NSW RURAL FIRE SERVICE

Your reference: SSD-13855453
Our reference: DA20210208000486-EIS & DA
Exhibition-1

State Significant - EIS & DA Exhibition - Industry

Grenfell Poultry Breeder Farm 1130 Gooloogong Road Grenfell NSW 2810, 22//DP866857

GRENFELL BUSH FIRE

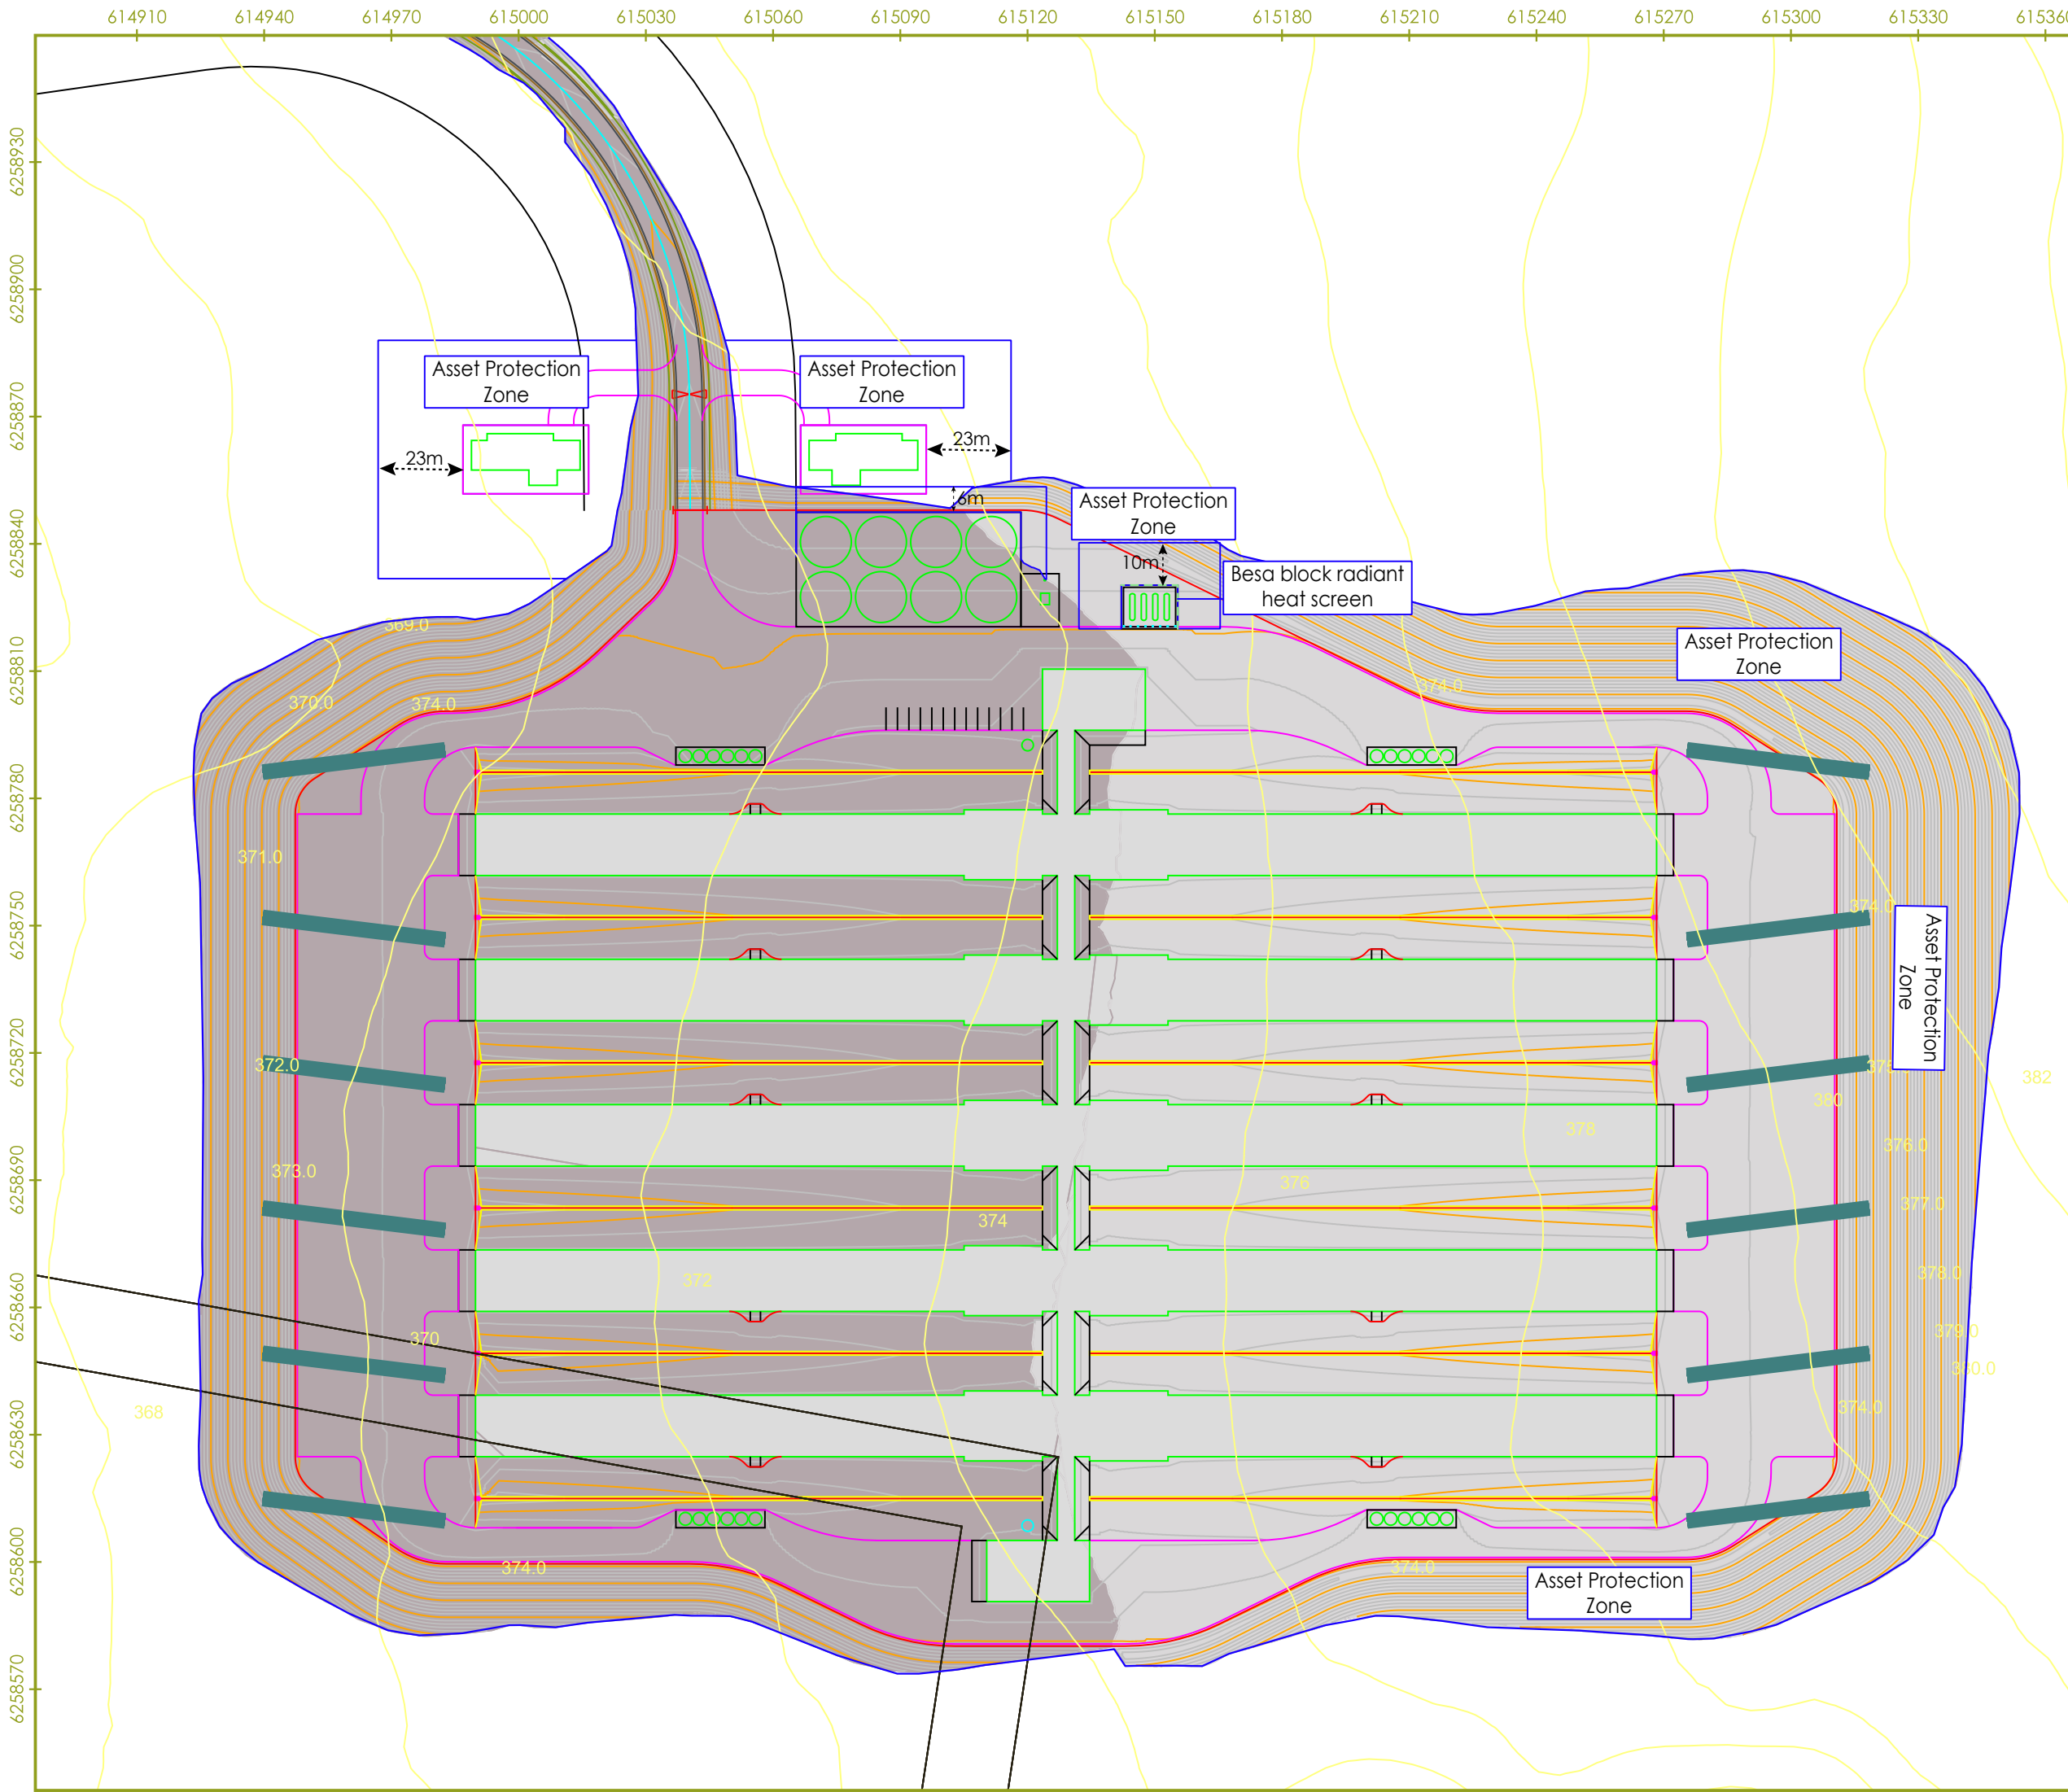
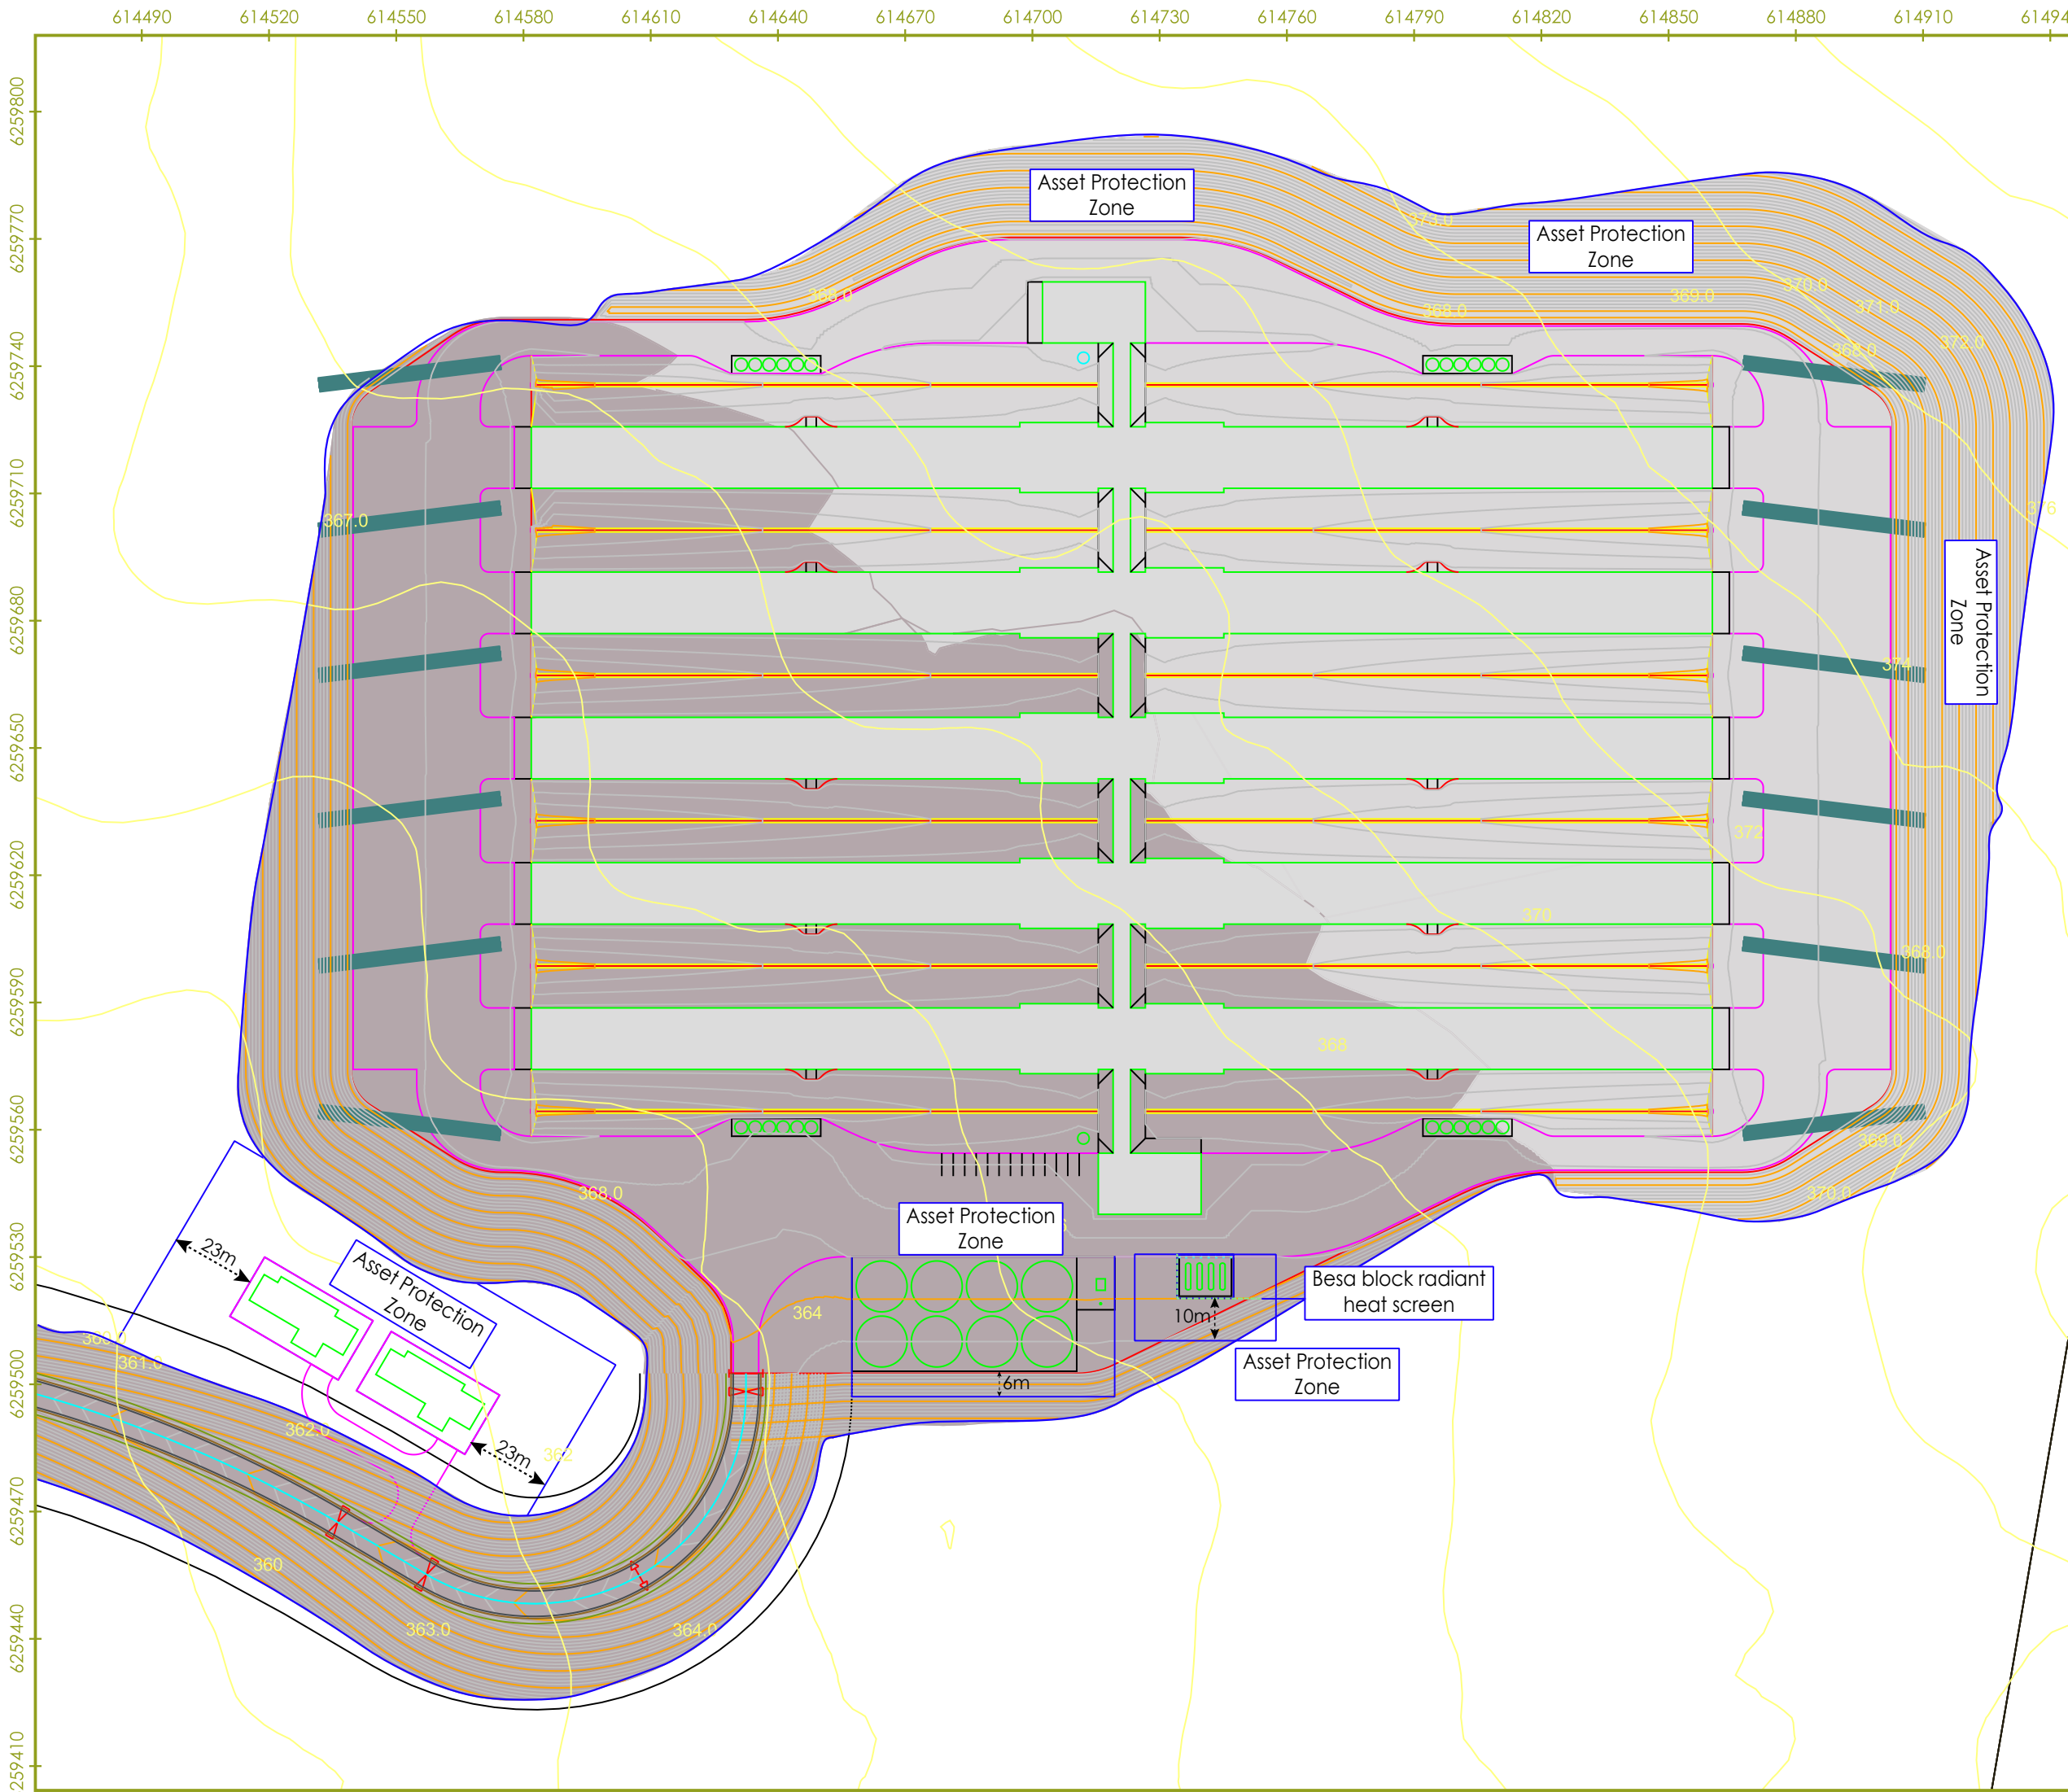
2. From the commencement of building works for each individual building, and in perpetuity to ensure ongoing protection from the impact of bush fires, asset protection zones must be provided around the facility buildings and residential building as identified in the 'Bush Fire Management Plan' prepared by Meridian Urban Pty Ltd (*Bush Fire Hazard Assessment and Management Plan*, dated 8 October 2021, Project Ref: 21-005, Rev. A). the asset protection zones are to be managed entirely as an inner protection area. When establishing and maintaining an inner protection area the following requirements apply in accordance with the requirements of Appendix 4 of *Planning for Bush Fire Protection 2019*:

5. A minimum 1.5 metre high radiant heat shield made of non-combustible materials must be constructed around the proposed LPG storage tanks, as identified in the 'Bush Fire Management Plan' prepared by Meridian Urban Pty Ltd (*Bush Fire Hazard Assessment and Management Plan*, dated 8 October 2021, Project Ref: 21-005, Rev. A). All posts and rails shall be constructed of steel. The bottom of the shield is to be in direct contact with the finished ground level or plinth.
